May 13, 2025

CONDITIONS OF APPROVAL - Project # PR-2025-011387/SI-2025-00040 - Site Plan-EPC

The purpose of this letter is to respond to the Post EPC Memorandum provided by City staff to the DFT, addressing comments on “Unapproved Changes” and Conditions 5-7.

# SAVIO RIDGE

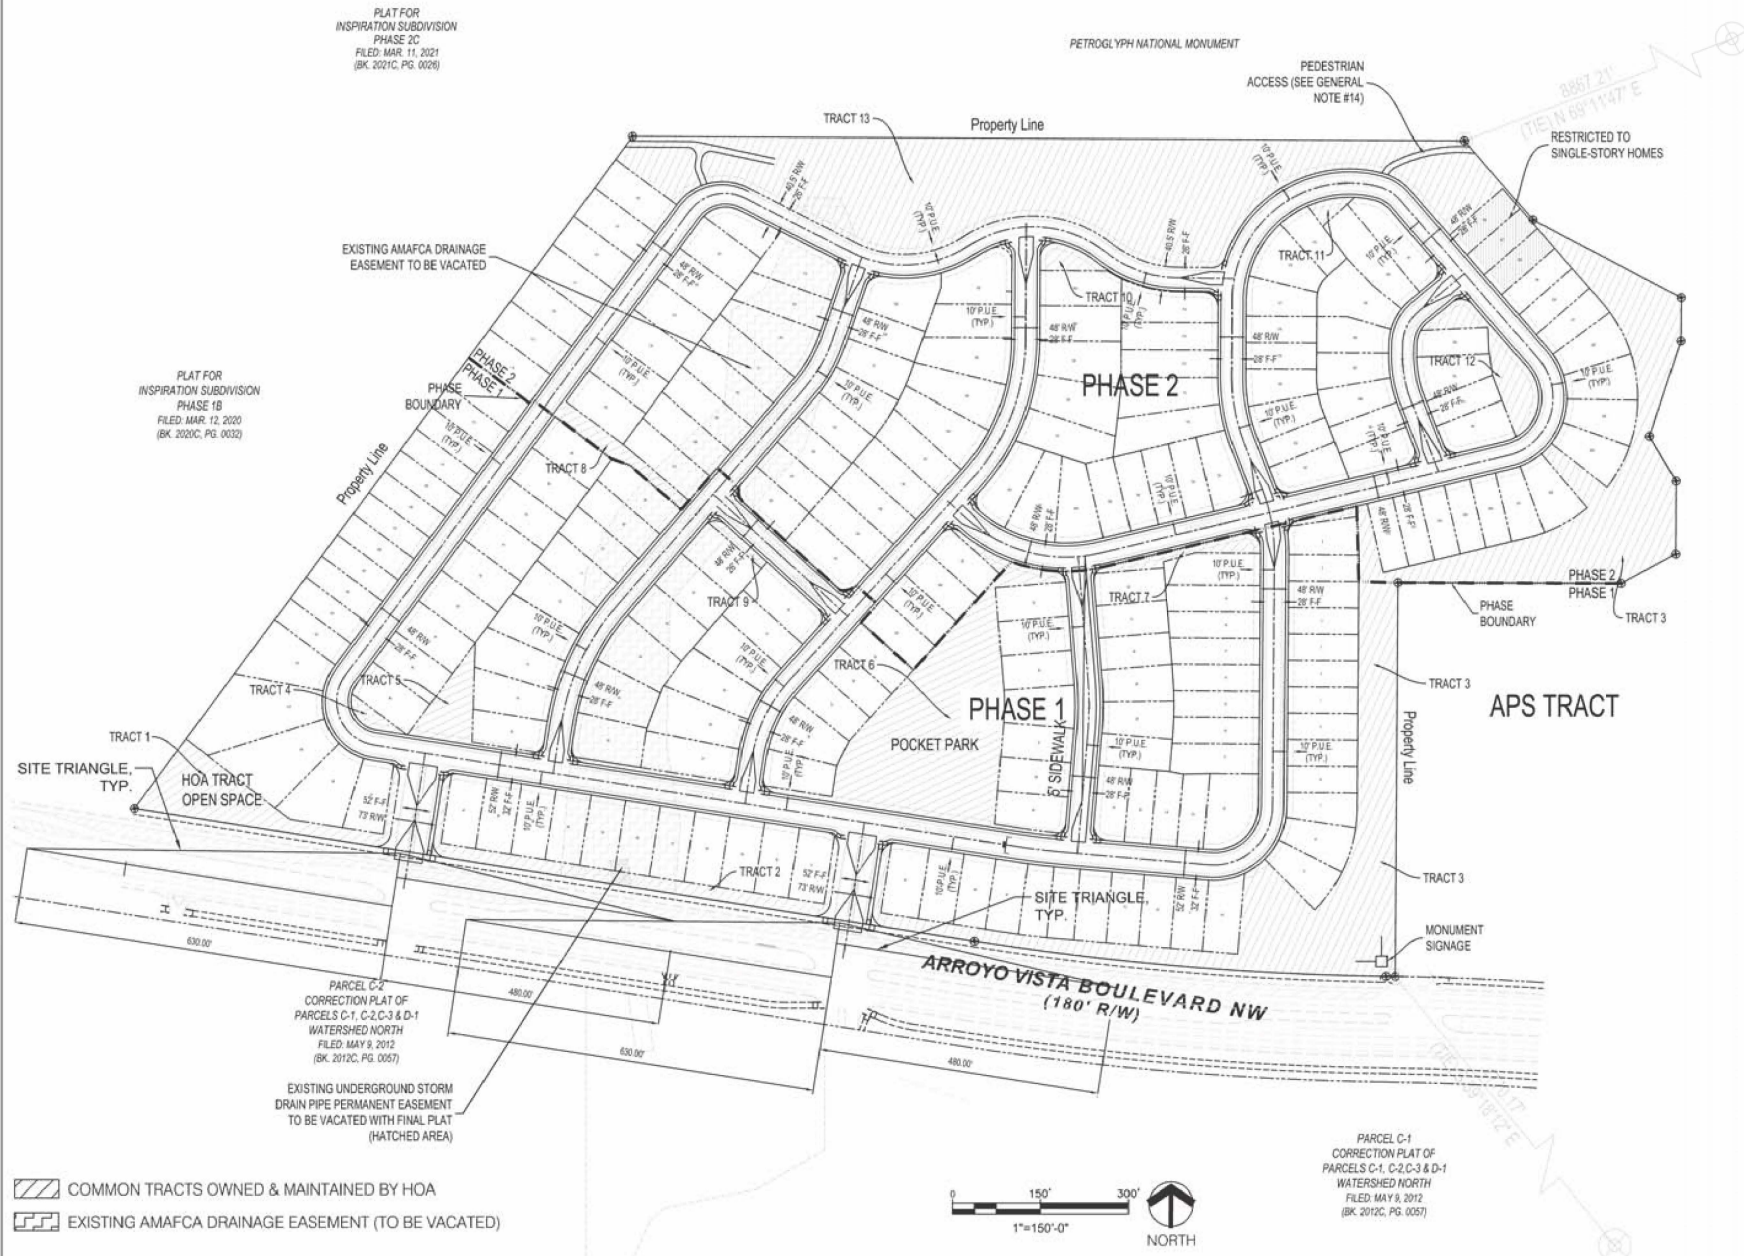
5. The proposed future waivers to the IDO and DPM requirements should be approved prior to final signoff of the Site Plan-EPC.

Condition 5 has been met. Please update text on the Site Plan sheet as requested below in 5c:

a) The proposed future waivers on the Site Plan to the DPM requirements have been approved by the DHO.

b) The IDO waiver was determined to not be required.

c) Please remove the IDO waiver that was not required from the Site Plan sheet. Please replace “FOR INFORMATIONAL PURPOSES ONLY” with “WAIVERS APPROVED BY THE DHO ON APRIL 23, 2025.”

Applicant response: *Site Plan has been updated with the text above.*

Sheet No.  
LP-1.2 10 of 21

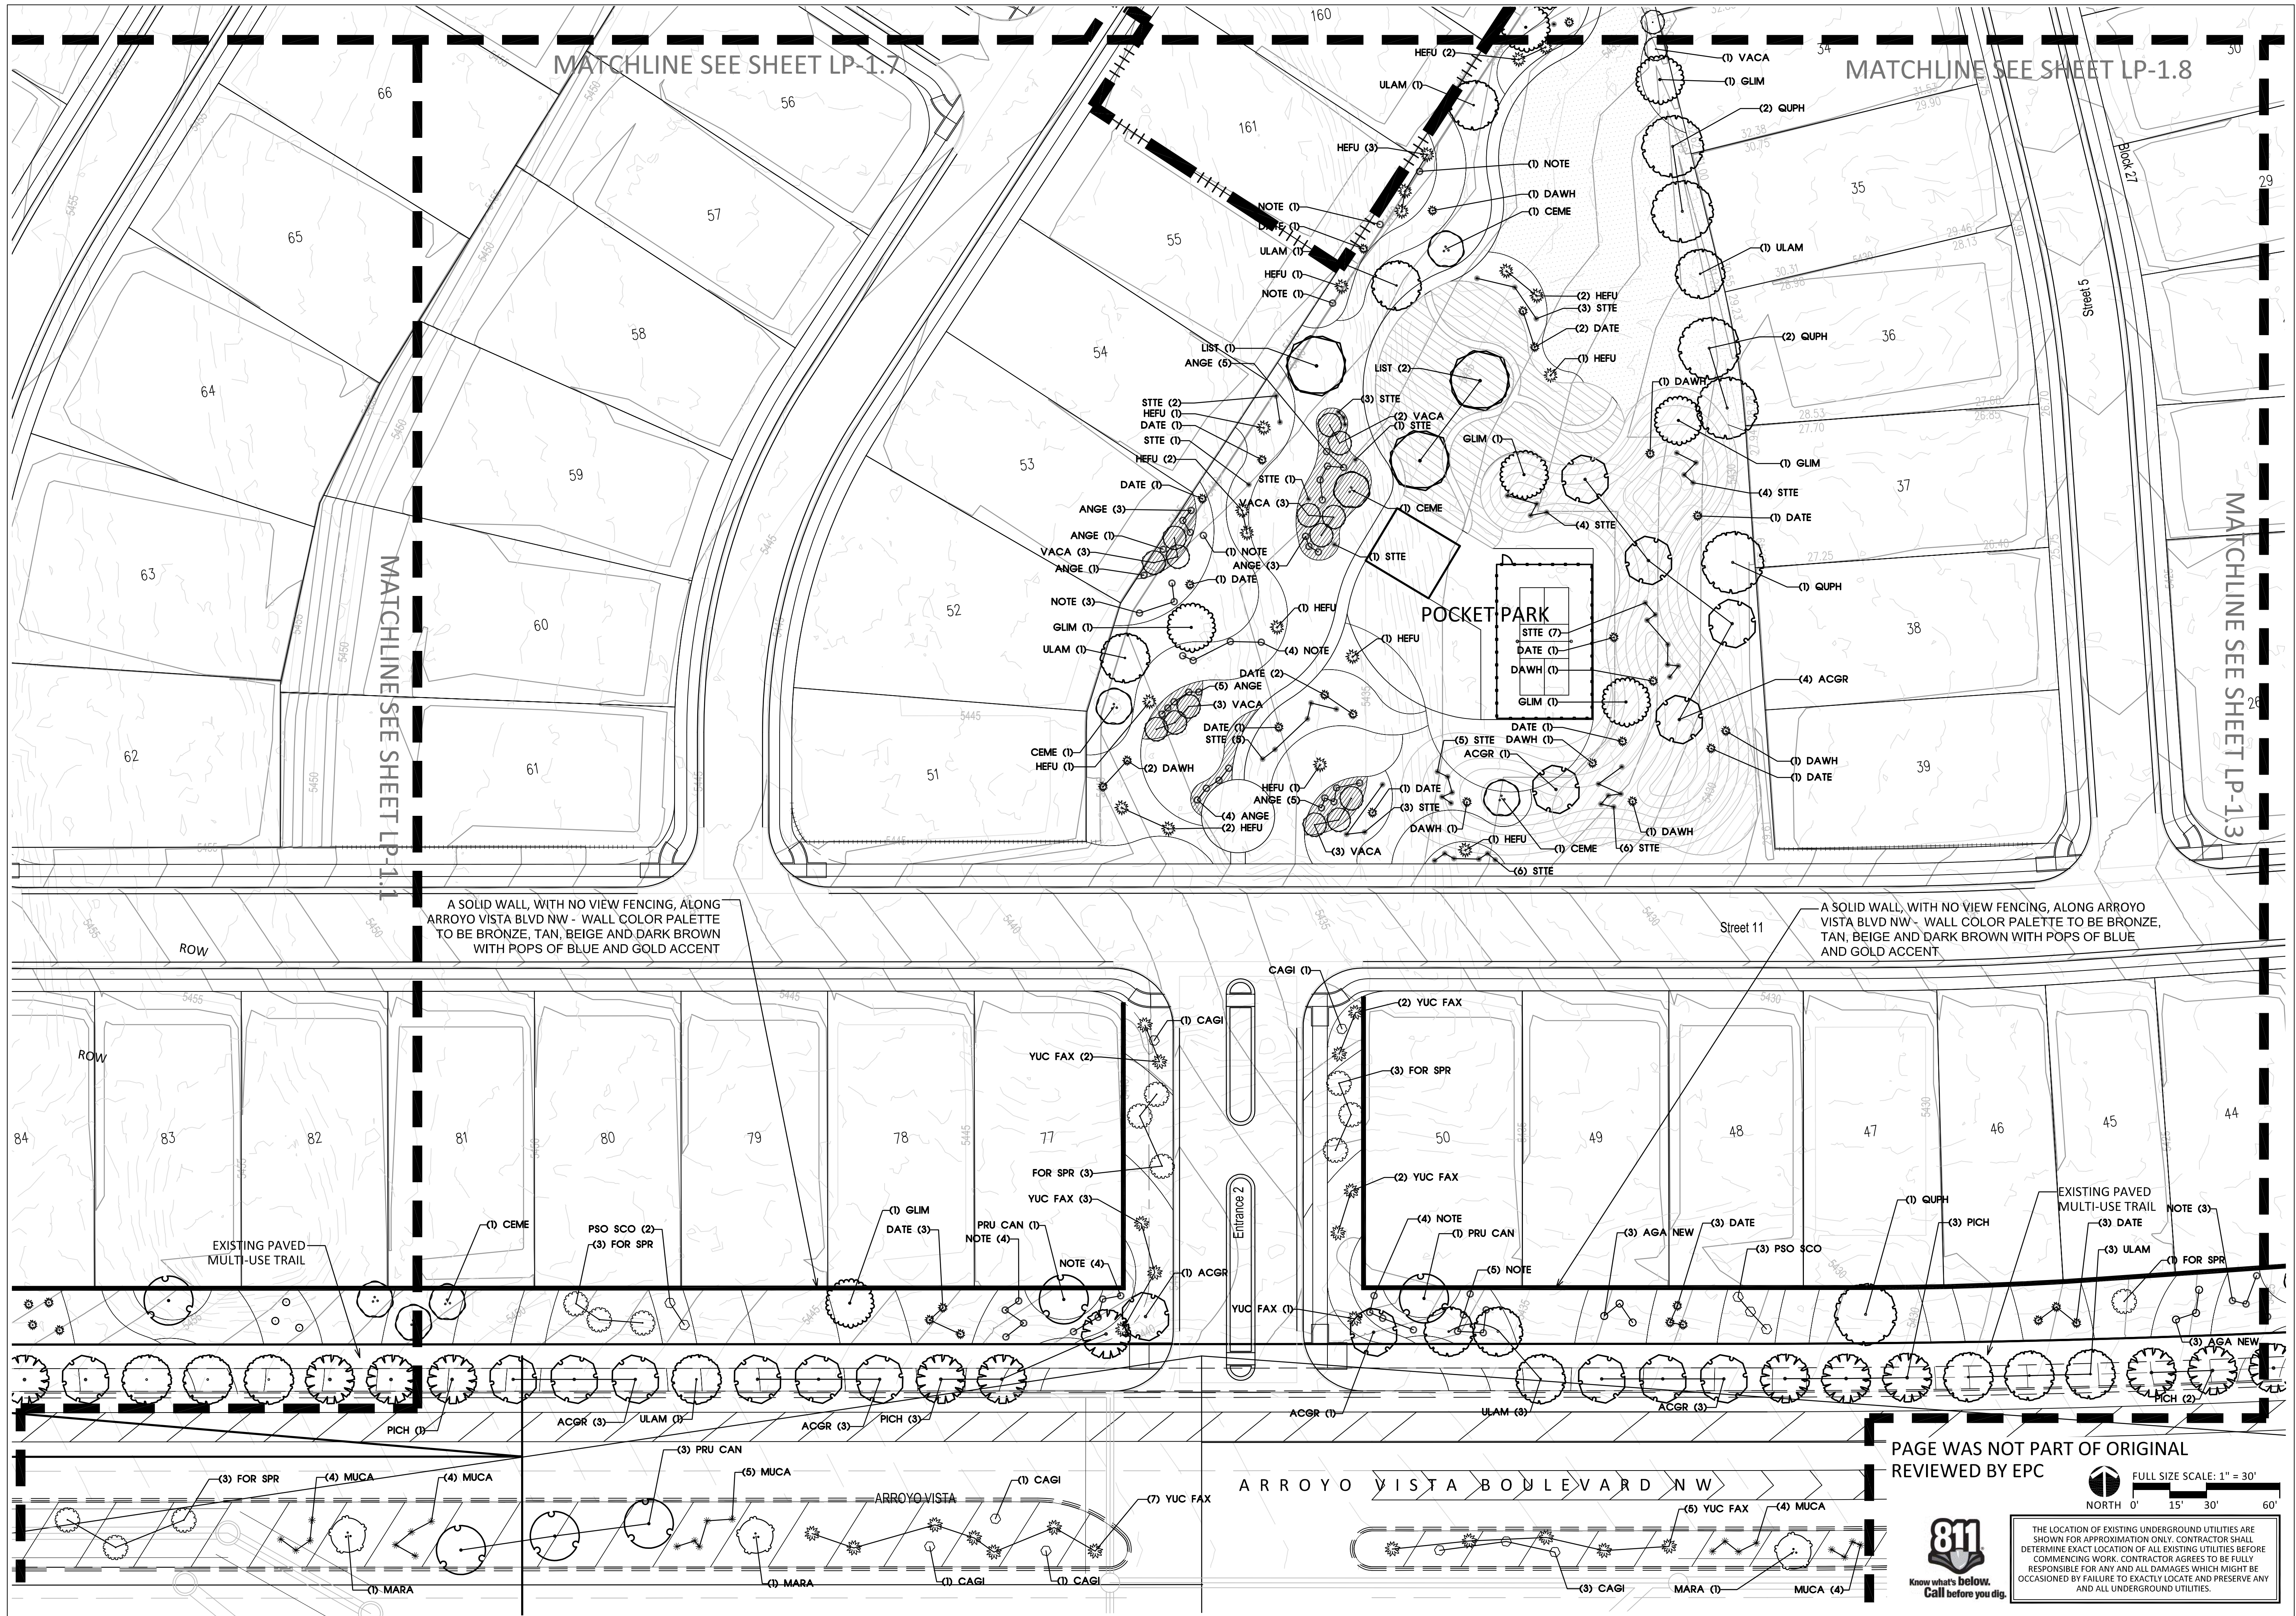
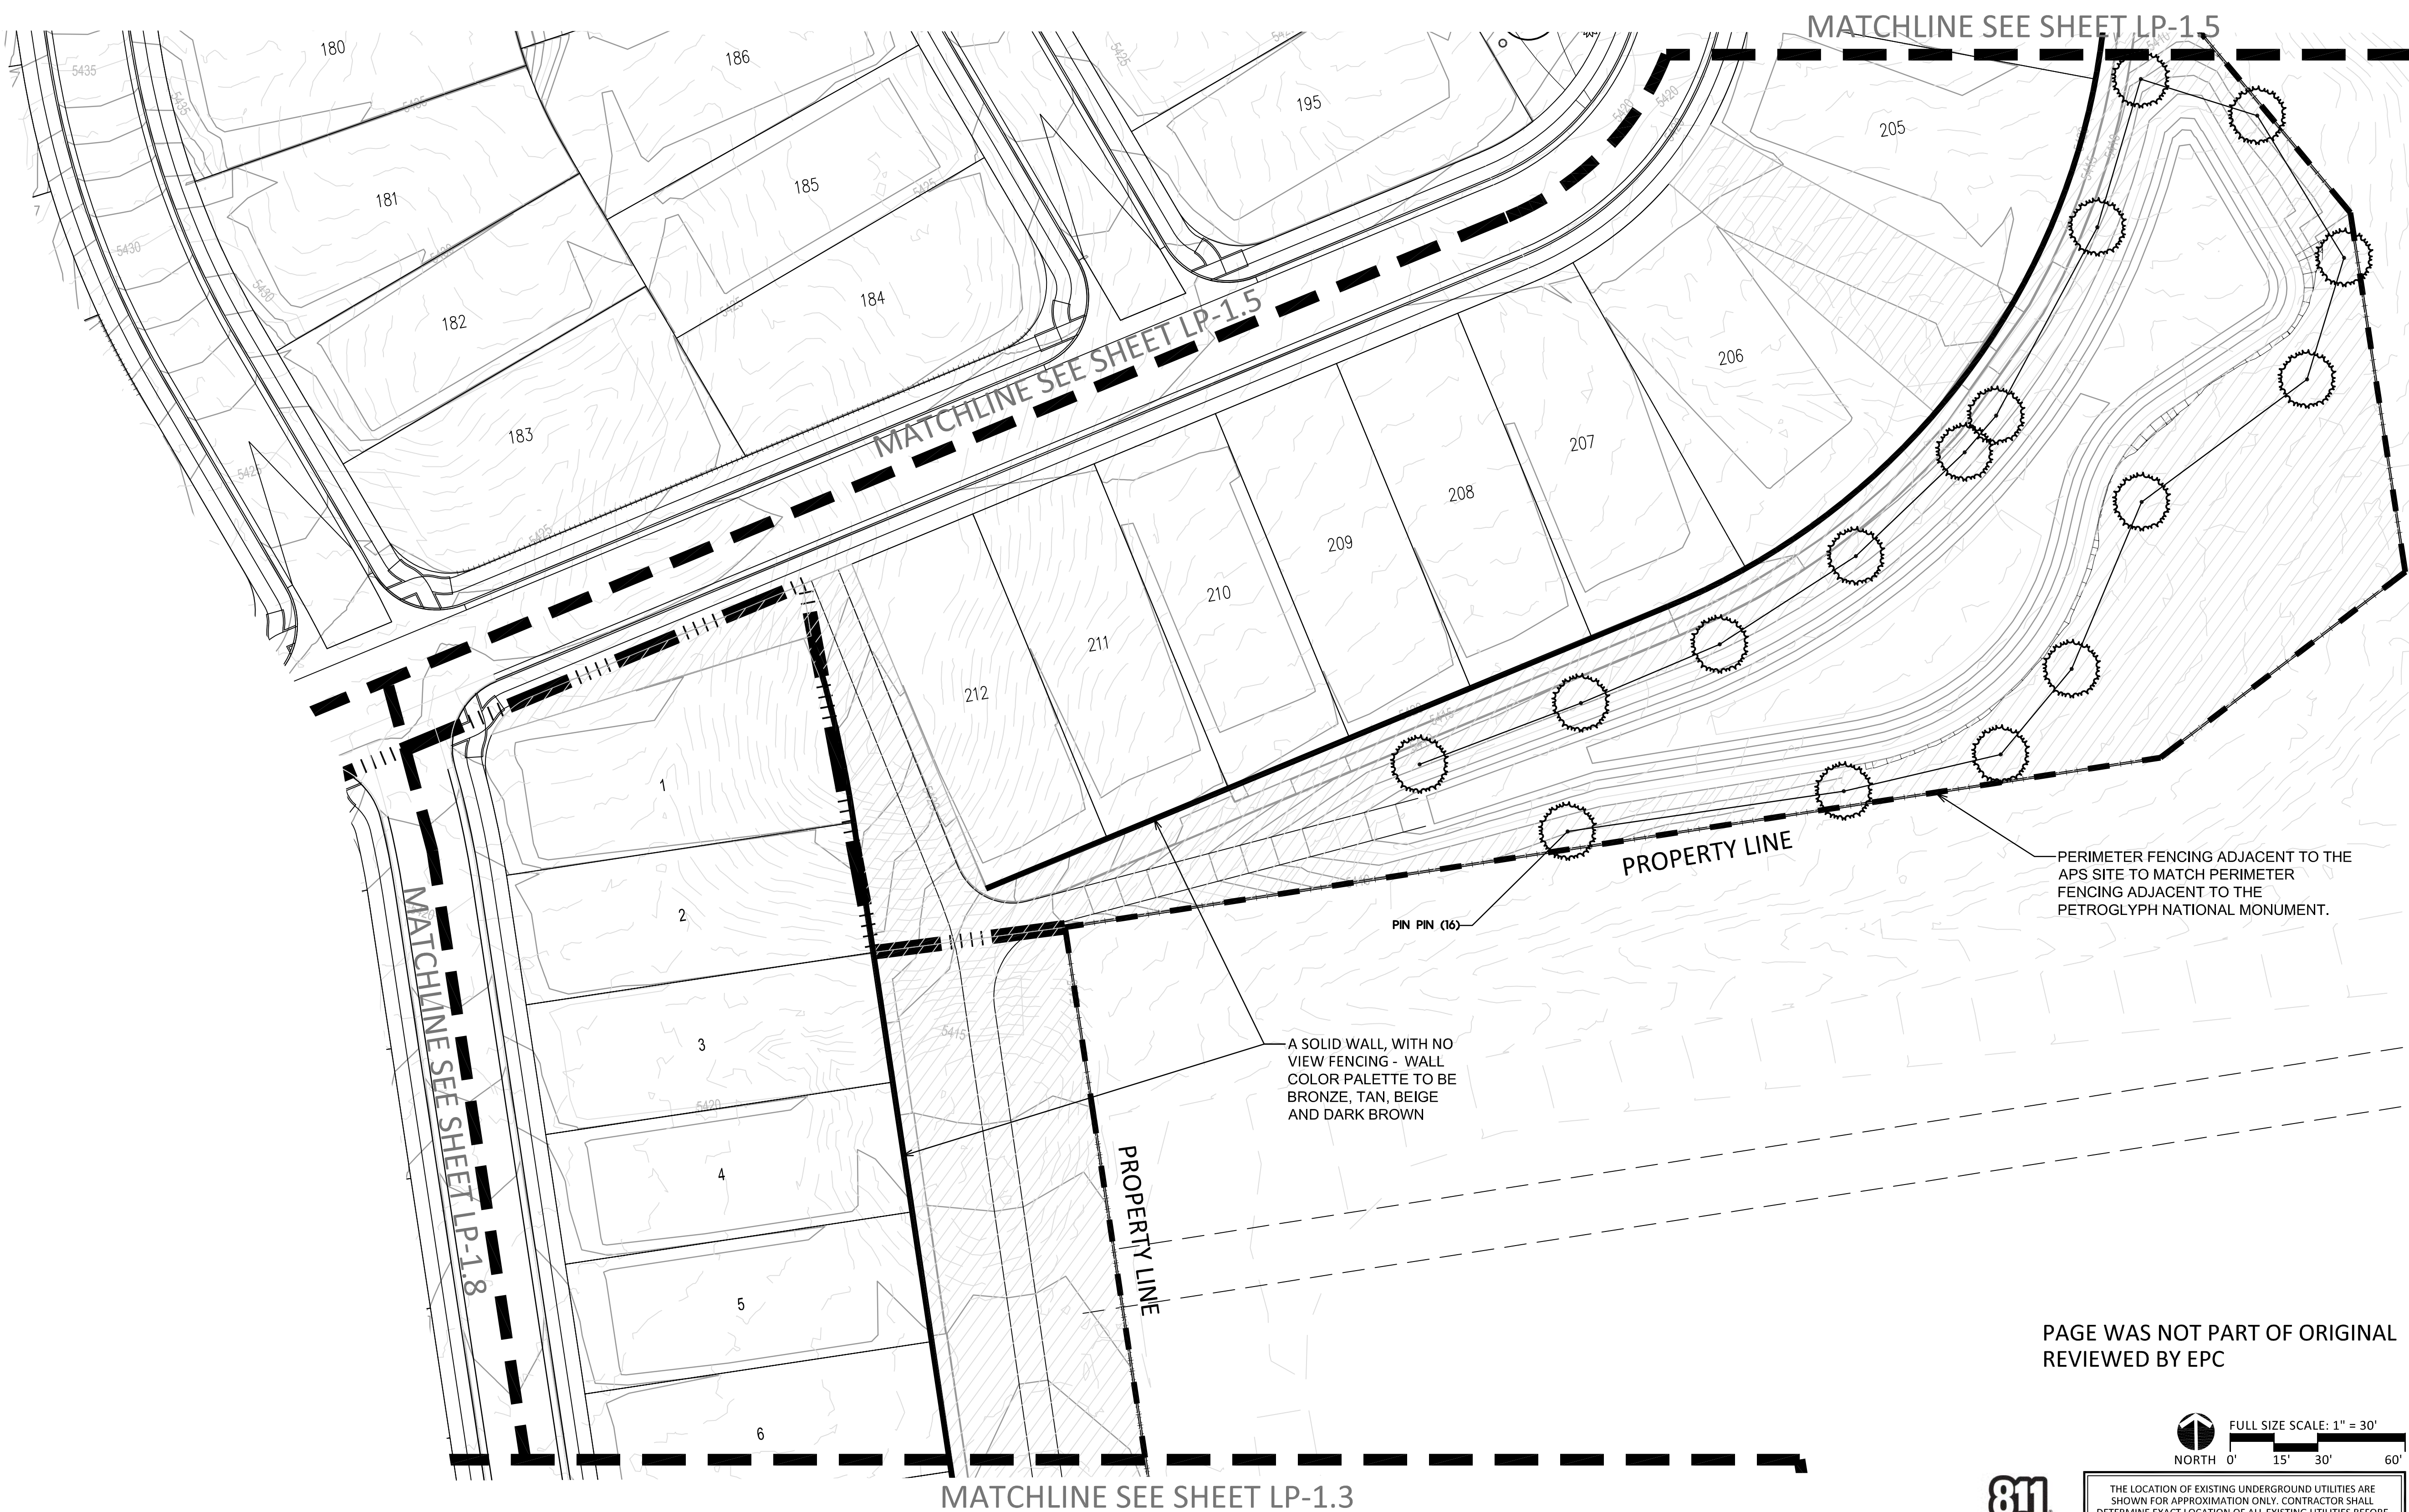
B. A solid wall with no view fencing along Arroyo Vista Blvd NW shall also be noted.

Staff has acknowledged that the applicant provided the “Walls” condition 7B on PLANTING NOTES & PLANT LIST sheet. The solid wall with no view fencing needs to be called out on the Site Plan sheet.

C. For the perimeter wall, a note shall be added that matches the color pallet of the entry gate wall: “overall color palette to be bronze, tan, beige and dark brown with pops of blue and gold accents.”

Staff has acknowledged that the applicant provided the “Walls” condition 7C on PLANTING NOTES & PLANT LIST sheet. The perimeter wall needs to be called out with the above “color palette” note on the Site Plan sheet.

Applicant response: This is called out on Sheets LP 1.1, 1.2, and 1.3.

Applicant response: This is called out on Sheets LP 1.1, 1.2, and 1.3.
